Project# 1001523
Application # 15DRB-70471
To be known as: ~~the~~ Ladona Business Park
AGENT: Rio Grande Engineering

Project# 1001523 – Ladera Business Park

14DRB-70016 – Major Site Development Plan for Building Permit

**RE: Site Plan for Subdivision
Preliminary-Final Plat
Ladera Business Park- Project# 1001523
Albuquerque, New Mexico**

Drawing file: Plans / L1.1 LANDSCAPE PLAN Albuquerque RV, LS-101a.pdf

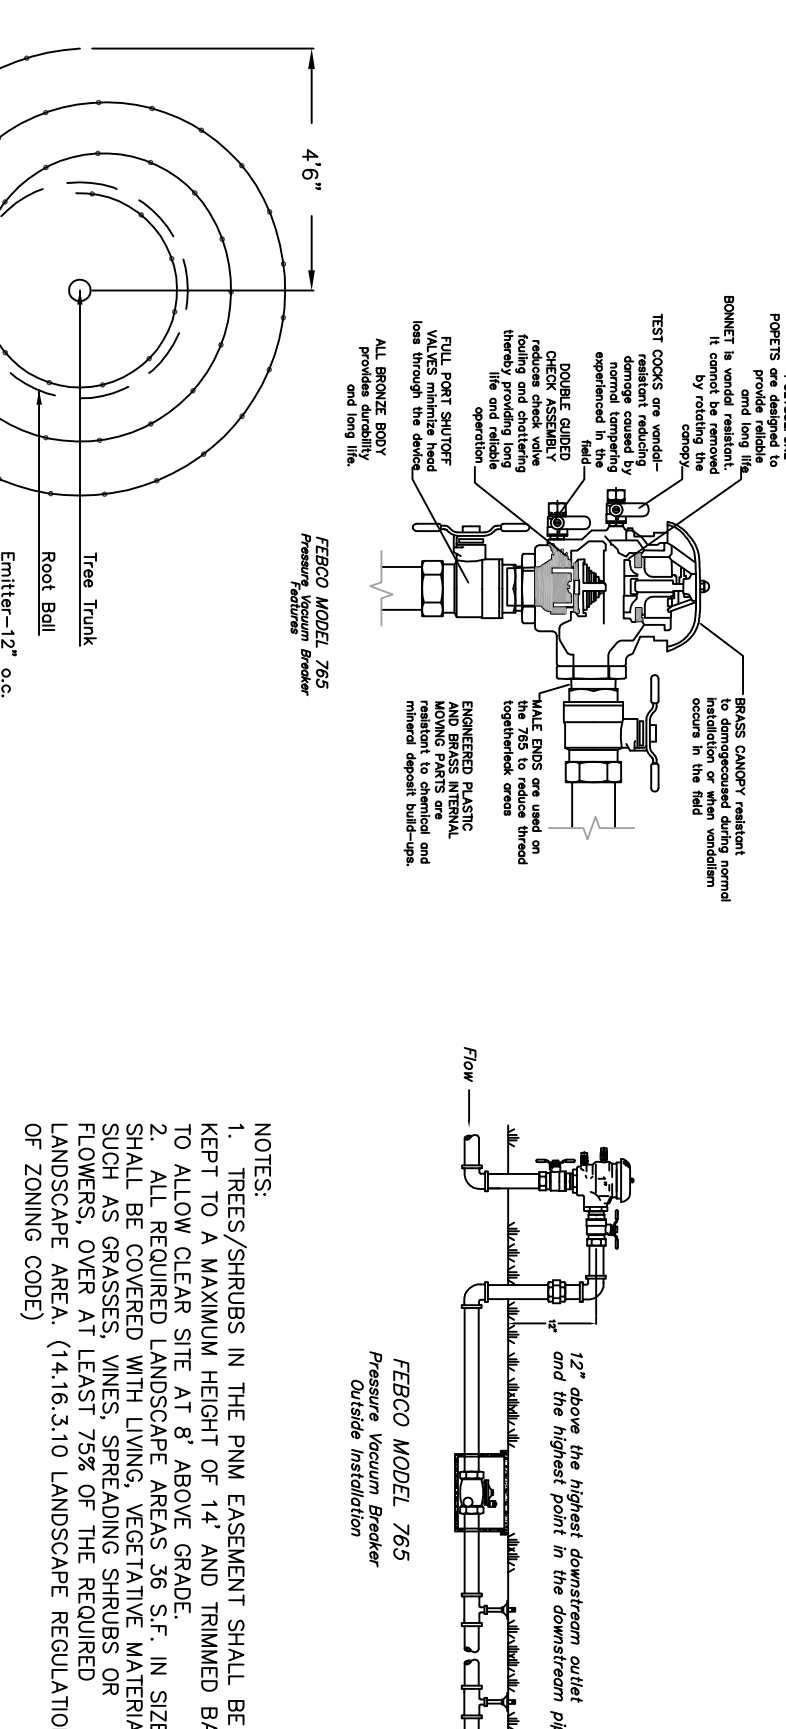
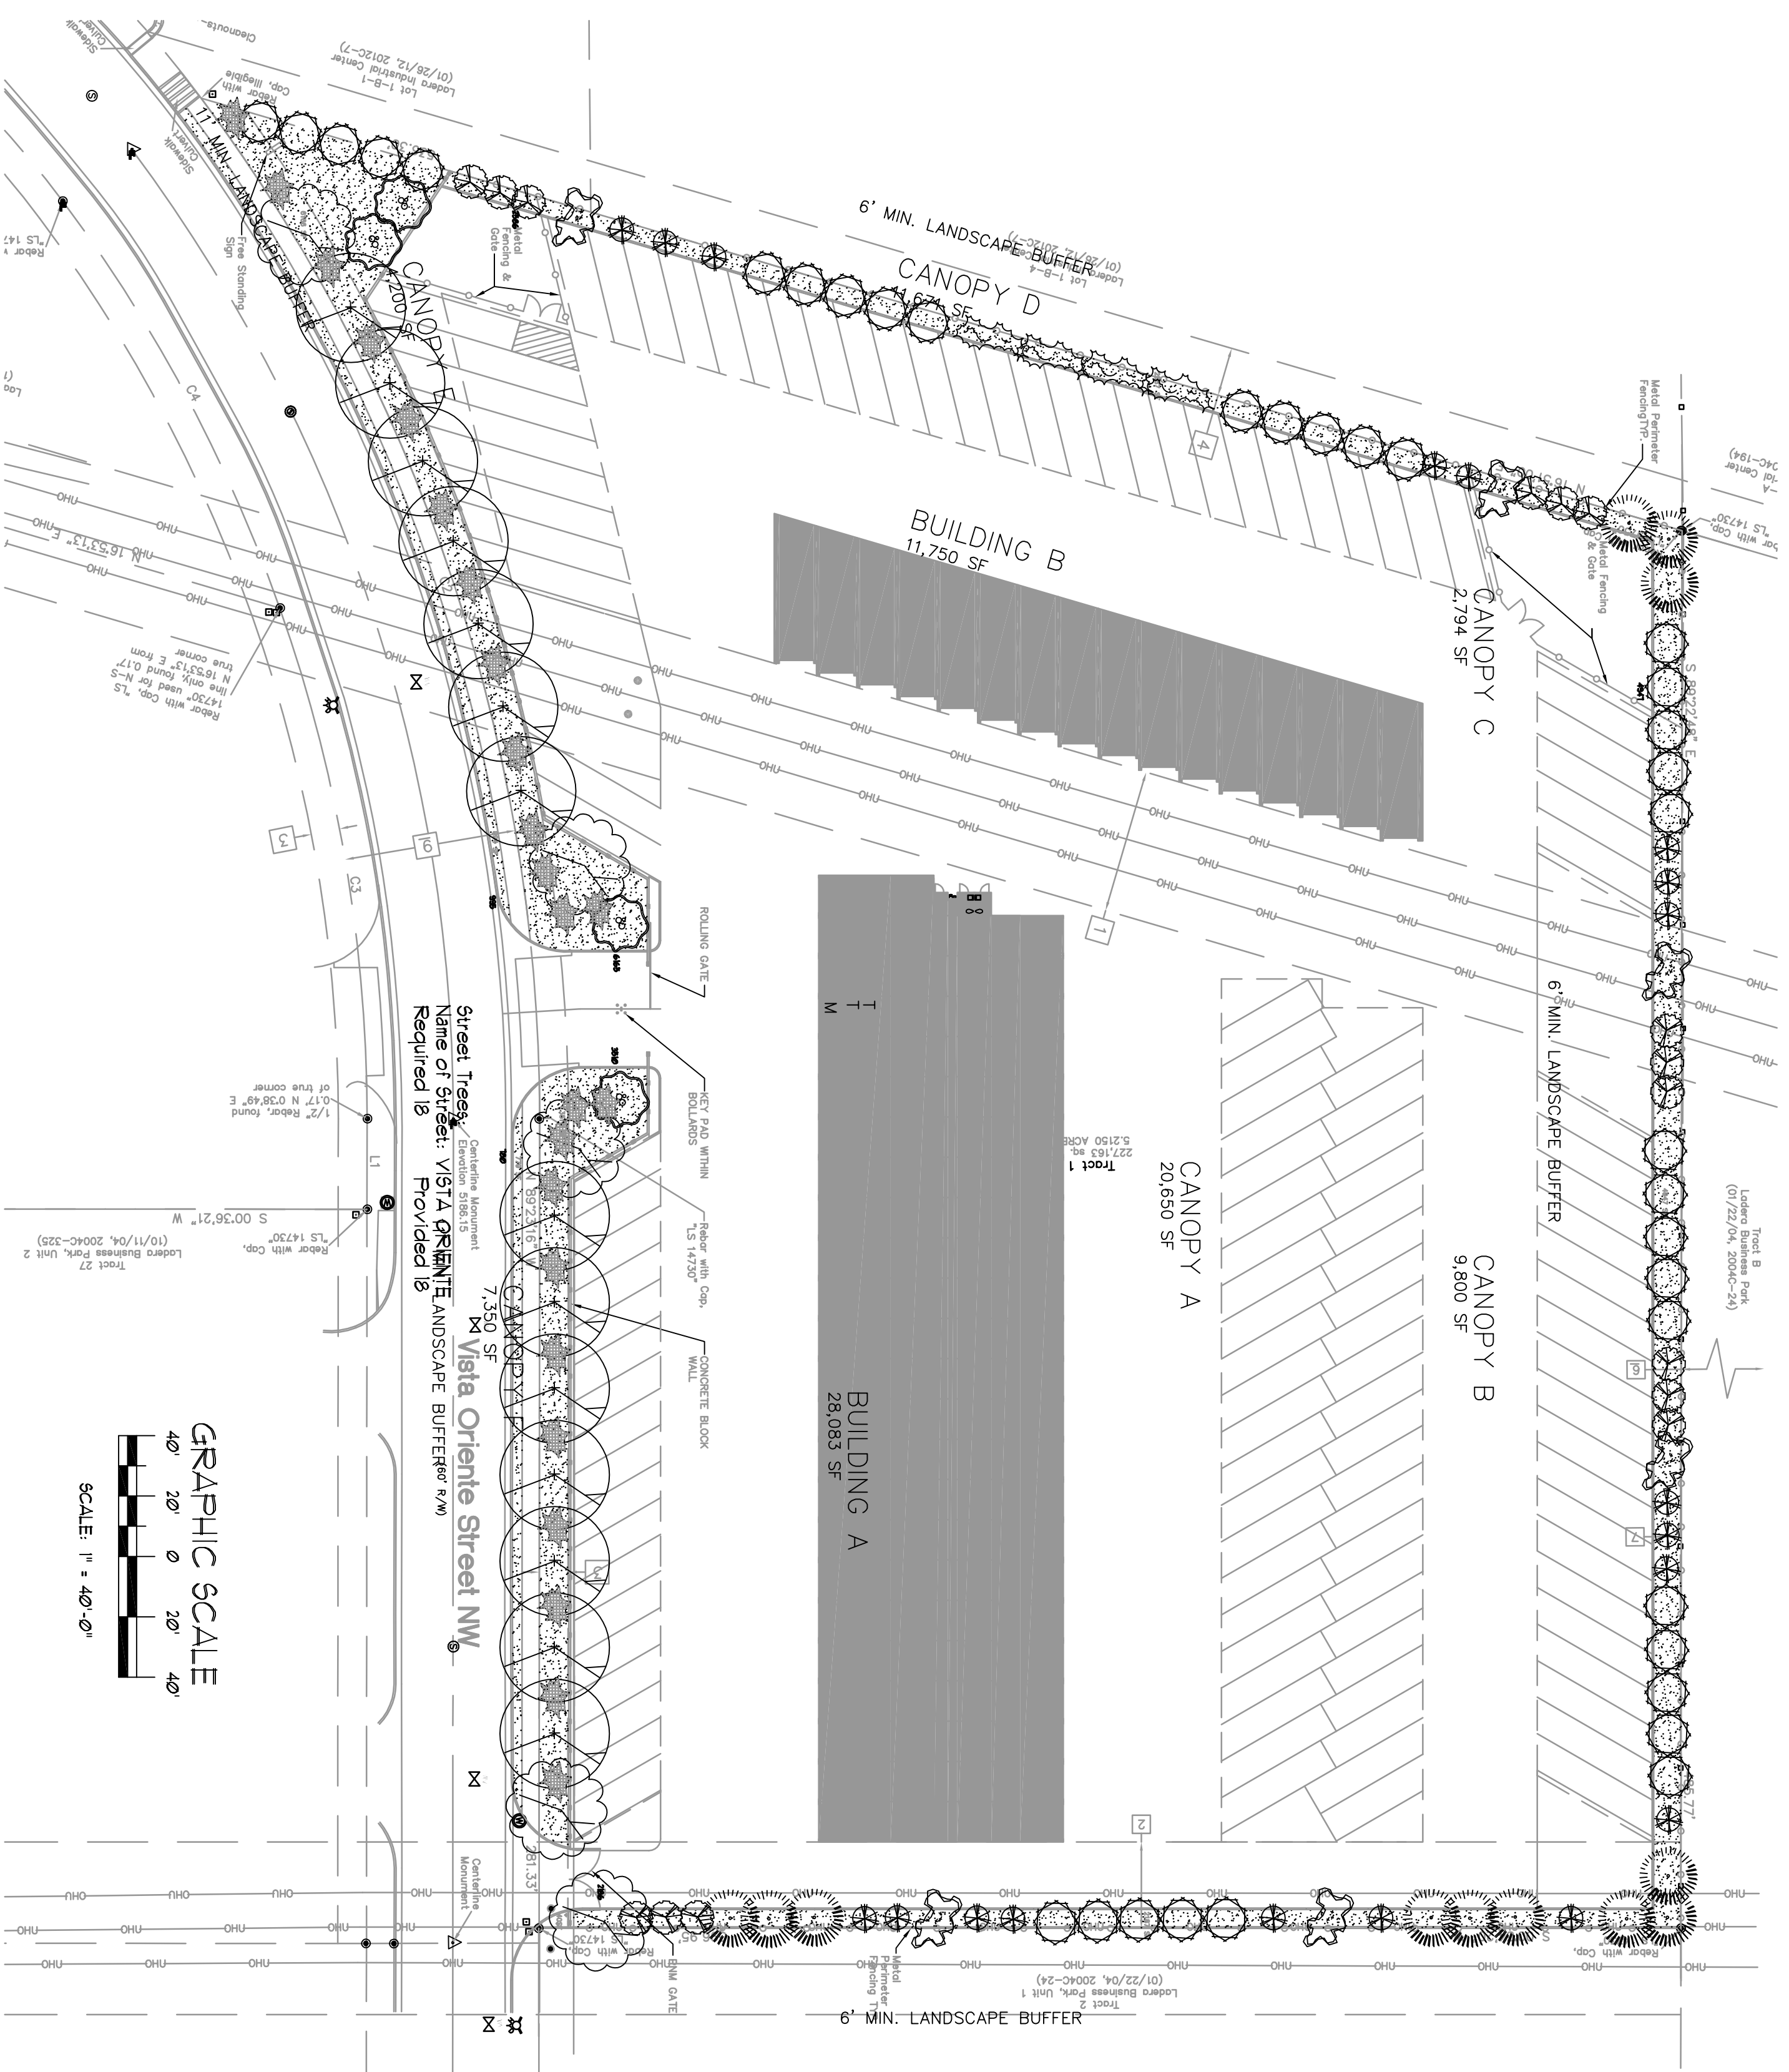
The Irrigation Plan is insufficient.

A Legend is needed for the Irrigation Plan.

Need to identify the point of connection for water service.

Need to show location of and detail of valves.

Identify location of controller.

Need the following specs:

Emitter

Bubbler (for trees)

PVC type

All irrigation in ROW must be to City Standards.
